Appendix E - Schedule of Amendments

SCOPE	DISCIPLINE	STAGE	DWG No.	REV.
-	A	CD	200-B1	P

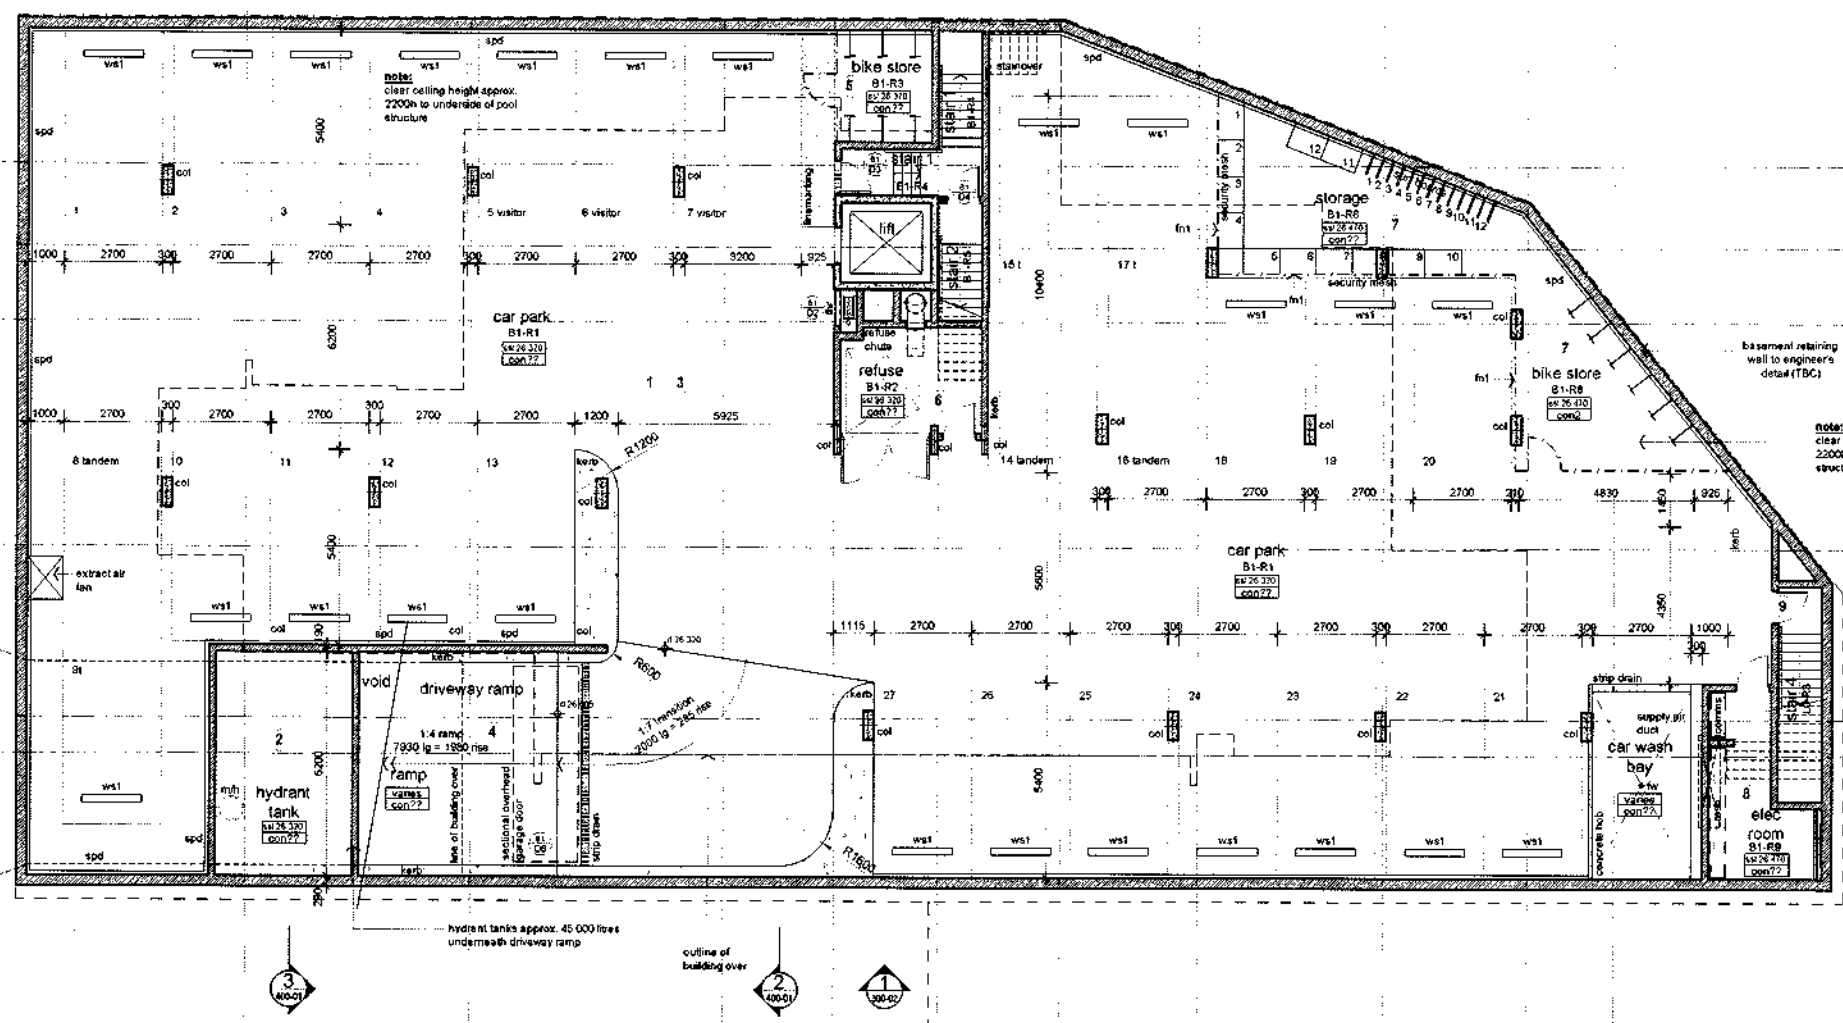
Drawing No.	DA revision	CD Revision	Comment No.	Description	Justification
200-B1	F	N	Basement General Arrangment Plan		
			1	Basement strcuture has been re-configured to suit strucutral design	Design Development
			2	Hydrant tank added to underside of ramp, water flow rate too low	Australian Standard
			3	Car park bays adjusted to suit new layout, 24 residentail + 3 visitors + 1 car wash bay = 28 total	Design Development
			4	Basement Entry ramp updated	DA Condition / BCA / Australian Standard
			5	Storage room adjacent stair lift and fire stair conveted into bike storage	DA Condition
			6	Refuse room enclosed	Design Development
			7	Storage area adjusted and bike storage added	DA Condition
			8	Electrcial room added	Design Development
			9	Stair 4 amended to suit new electrcial room, communal toilet and egress from basement	BCA / Design Development
200-00	G	P	Ground Floor General Arrangment Plan		
			1	Water Meter added	Design Development

SCOPE	DISCIPLINE	STAGE	DWG No.	REV.
-	A	CD	200-00	P

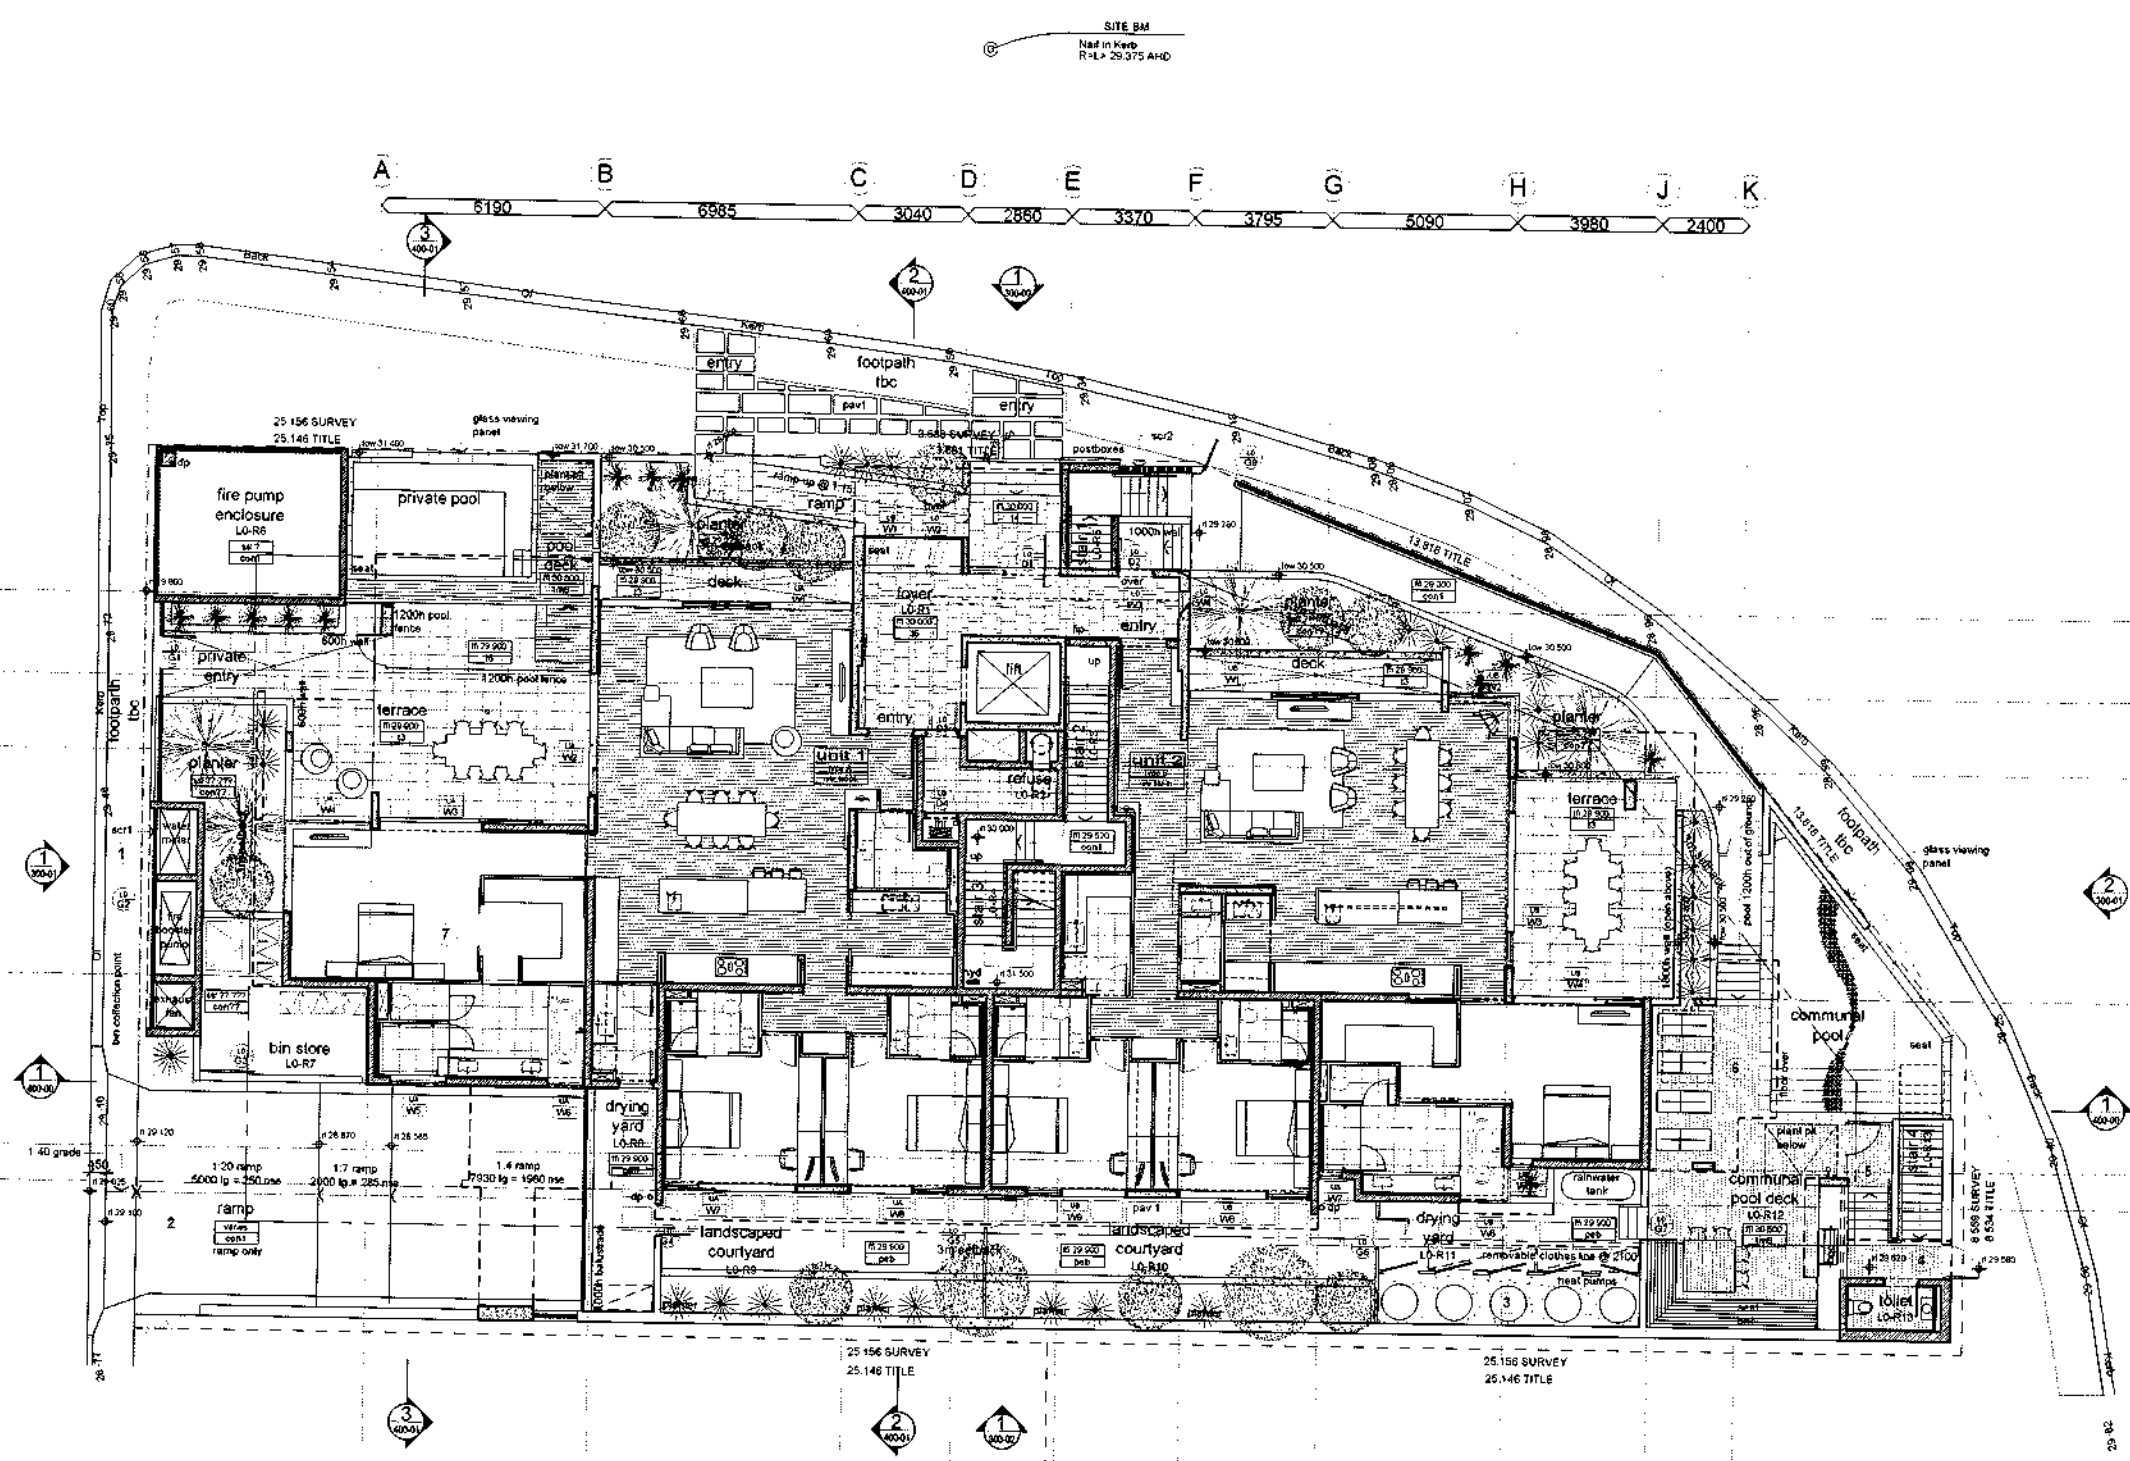
2	Basement Entry ramp updated	DA Condition / BCA / Australian Standard
			3	Heat pumps added	Basix Report
			4	Communal toilet added	BCA
			5	Stair 4 amended to suit new electrcial room, communal toilet and egress from basement	BCA / Design Development
			6	Pool and deck adjusted to addition of toilet and amended stair	Design Development
			7	Unit 1 Bedroom / Robe / Ensuite re-configuration	Design Development
200-01	F	N	L1 - L5 General Arrangment Plan		
			1	Unit 3,5,7,9 + 11 Foyer Amended to suit fire egress strategy	Design Development
			2	Unit 3,5,7,9 + 11 Entry amended to suit fire egress strategy	Design Development
			3	Refuse layout amended to suit fire egress strategy	Design Development
			4	Window configurations amended	Basix Report / Design Development
			5	Sunhood / Awning orientation amended to alternate floors	Design Development
			6	Buidling form re-designed to suit council set back requirements. Windows added and re-configured	Basix Report / Design Development

7	Drying court enclosed	Design Development
210-00		M	Roof Plan		
			1	Flat roof extent to façade amended	Basix Report / Design Development
			2	Sunhood / Awning / Fire spandrel added	BCA
			3	Plant enclosure roof removed (height restriction)	DA Condition
300-00	I	P	Elevation - Norh East		
			1	Sunhood / Awning / Fire spandrel added	BCA
			2	Private pool wall / noundary fence amended	Design Development
			3	Glazing suites amended	Basix Report / BCA / Design Development
			4	Stone cladding removed from columns	Design Development
300-01	I	P	Elevation - Norh West + South East		
			1	Façade updated to suit setback requirements	DA Condition
			2	Timber screen added to carpark entry	DA Condition
			3	Boundary fence / services allocation updated	Design Development
			4	Communal pool area / boundary wall updated	BCA / Design Development
			5	Sunhood / Awning / Fire spandrel added	BCA
			6	Roof form consolidated	Design Development

SCOPE	DISCIPLINE	STAGE	DWG No.	REV.
-	A	CD	300-00	Q

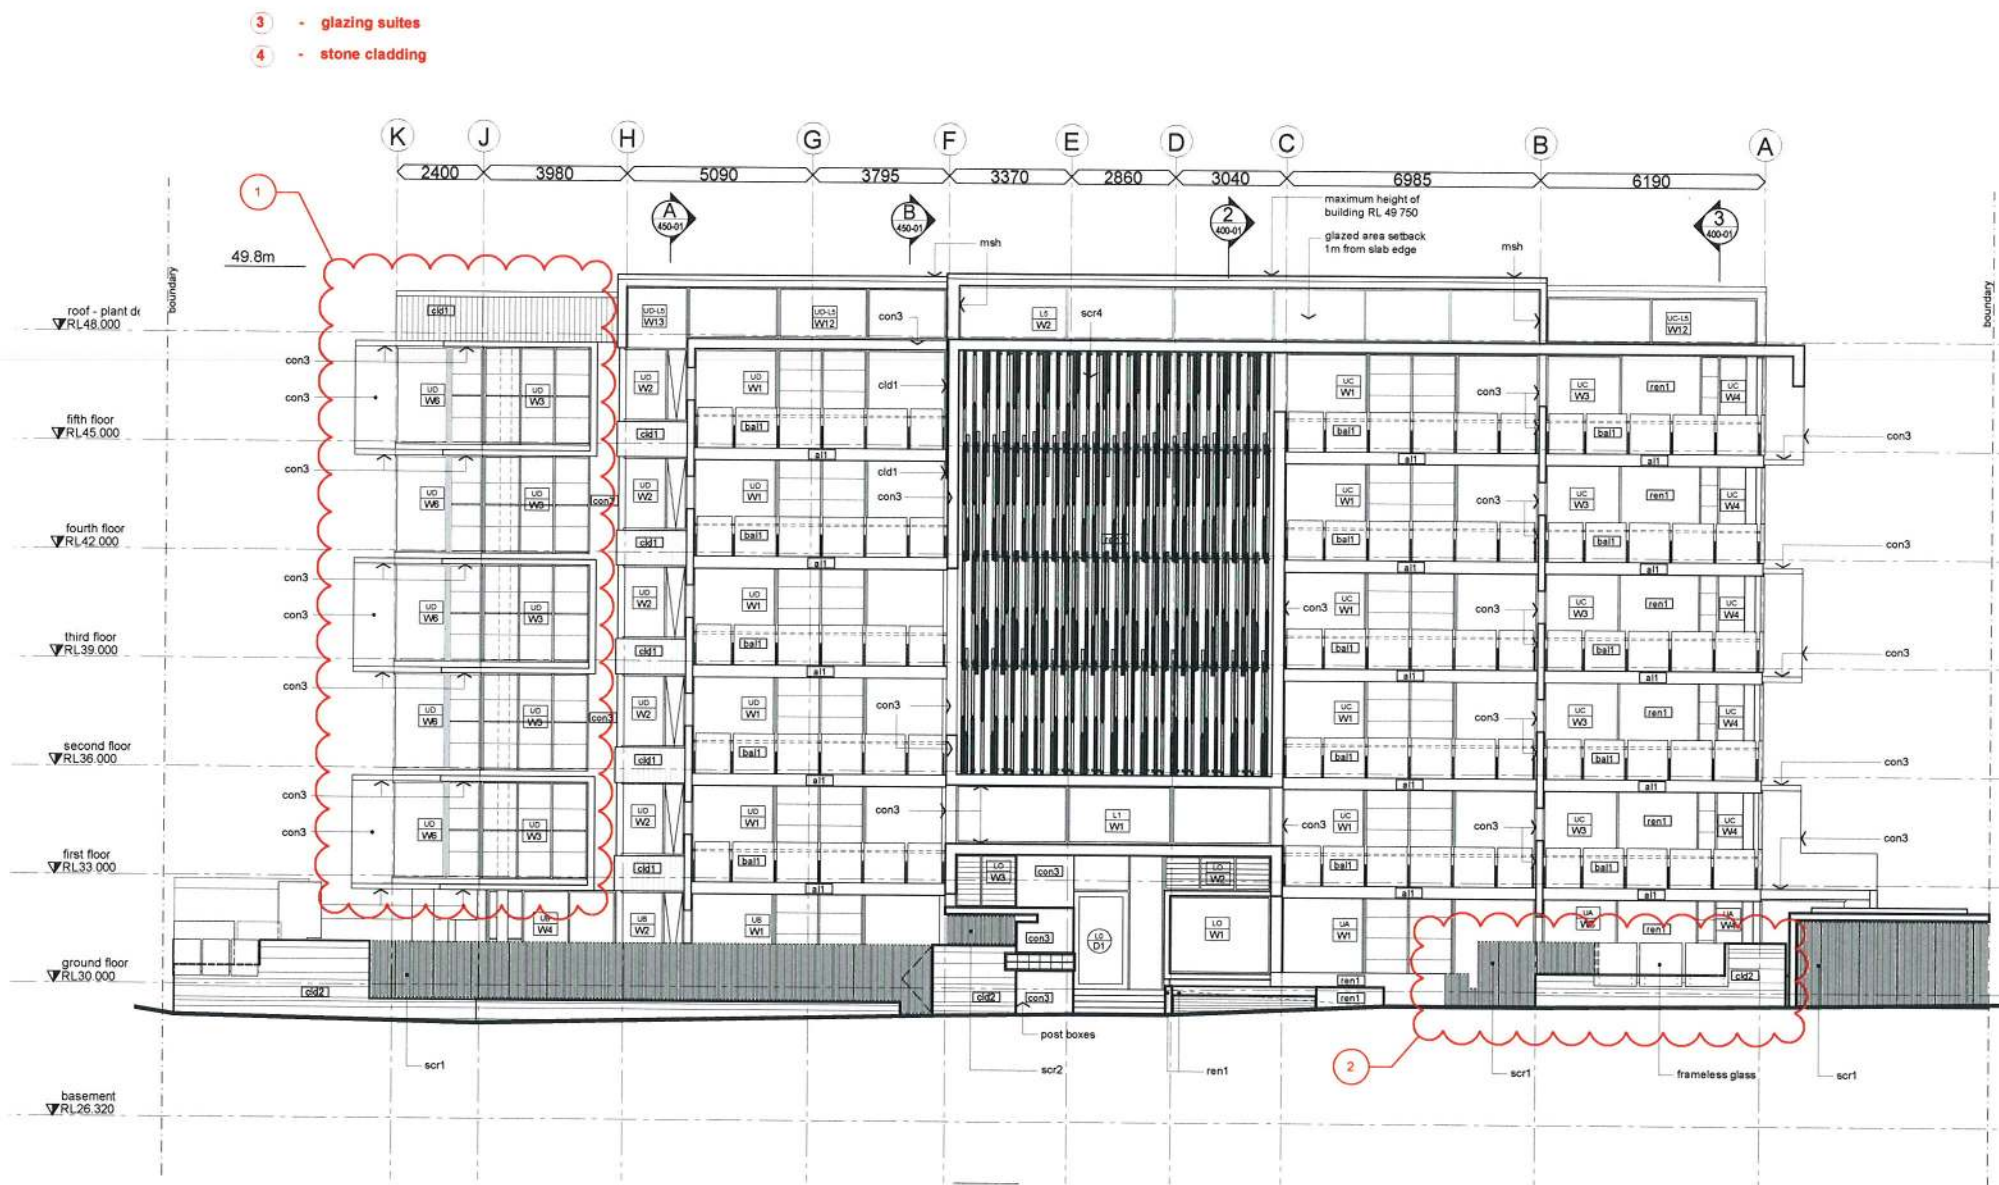
7	Glazing suites amended	Basix Report / BCA / Design Development
			8	Stone cladding removed from columns	Design Development
300-02	I	P	Elevation - Norh West + South West		
			1	Perimter wall and structure amended	Design Development
			2	Drying court enclosed	Design Development
			3	Glazing suites amended	Basix Report / BCA / Design Development
400-00	E	J	Section A-A		
			1	Rear corner / façade amended	DA Condition
			2	Basement Entry ramp updated	DA Condition / BCA / Australian Standard
			3	Stair 4 amended to suit new electrcial room, communal toilet and egress from basement	BCA / Design Development
			4	Glazing suites amended	Basix Report / BCA / Design Development
400-01	G	L	Section B-B + section C-C		
			1	Rear aluminium screen developed	Design Development
			2	Plant enclosure roof removed (height restriction)	DA Condition
			3	Feature timber screen developed / strcutre consolidated	Design Development

2 Screen Detail - Elevation
300-00 1:50

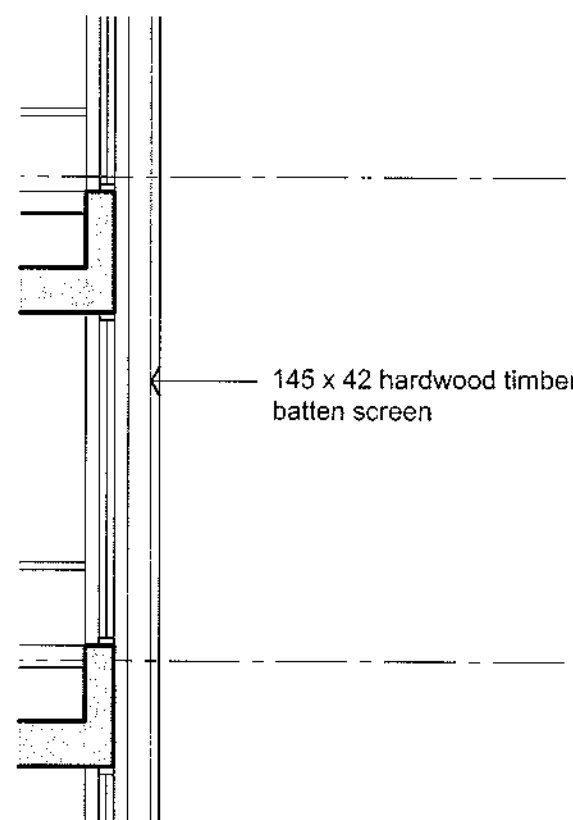
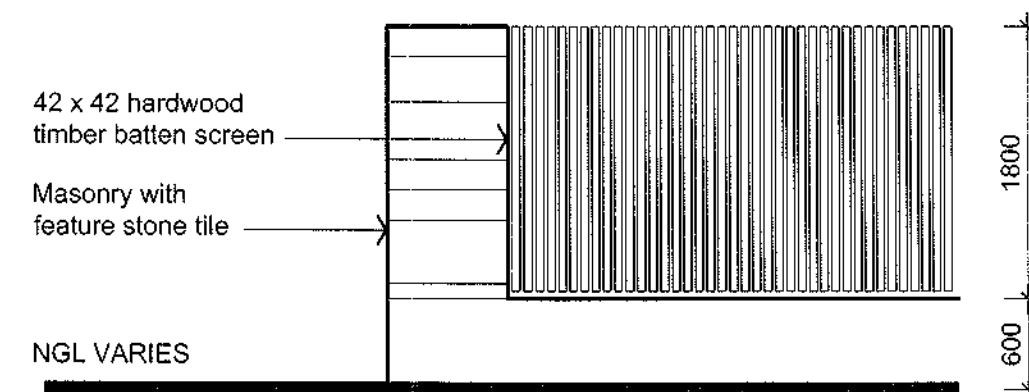
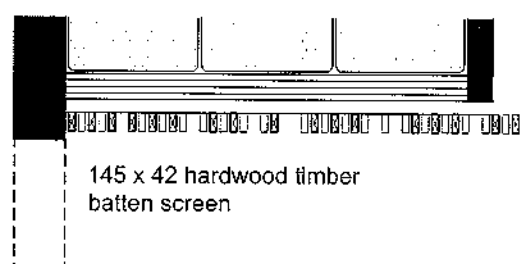
4	Private pool consolidated	Design Development
			5	Façade updated to suit setback requirements	DA Condition
			6	Timber screen added to carpark entry	DA Condition
			7	Glazing suites amended	Basix Report / BCA / Design Development
650-01	A	650-00 (A)	Screen Details		
			1	Feature timber screen developed / strcutre consolidated	Design Development
